STATE OF WASHINGTON
DEPARTMENT OF ECOLOGY

Re: CU-14-00005

Thank you for the opportunity to comment during the optional determination of nonsignificance process for the farming operations related to KC 17.15.060.1 A – Marijuana Processing and Production on a 15.03 acres parcel, proposed by Mary Gonzalez. We have reviewed the documents and have the following comments.

Drawing file: CU-14-00005 McDonald / CU-14-00005 McDonald Site Plan.pdf

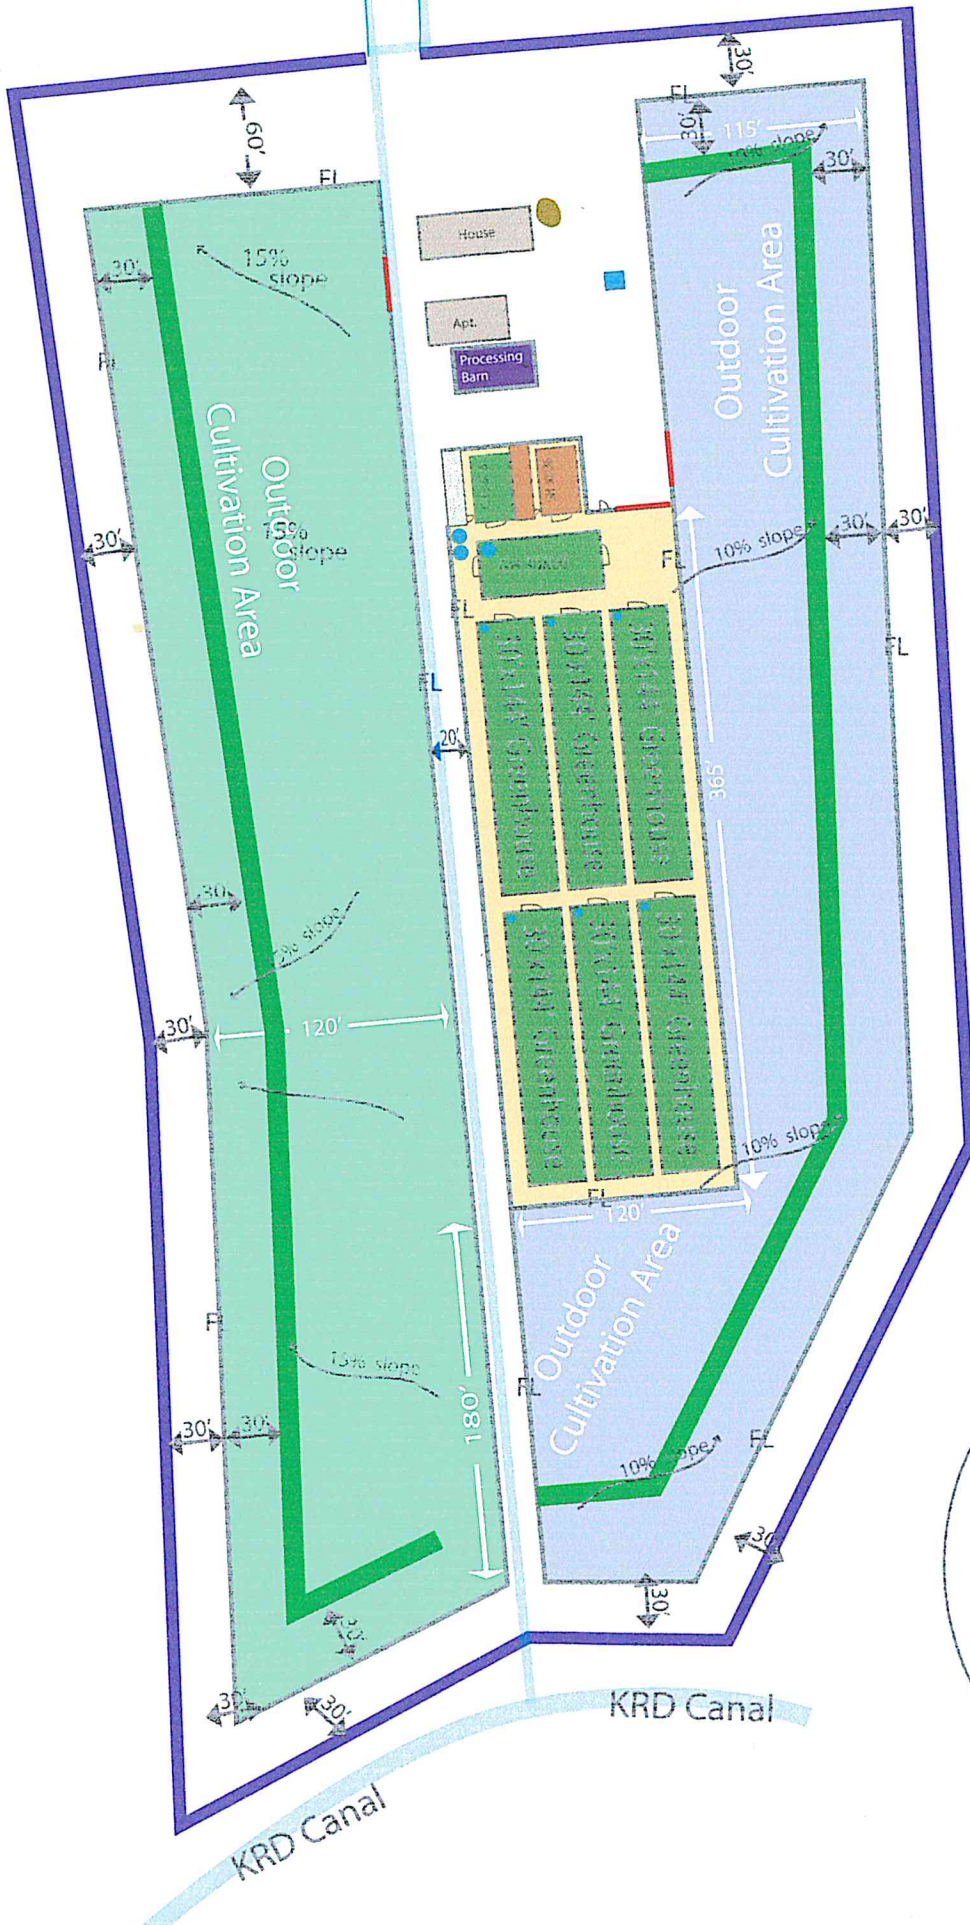
Ecology recommends that all phases of the commercial cannabis growing development be described in this environmental checklist form. A site plan was available, but very little details of the plan were included in the environmental checklist answers. No build-out information, such as total square feet of impervious surfaces or square feet per phase, was provided to this reviewing agency.
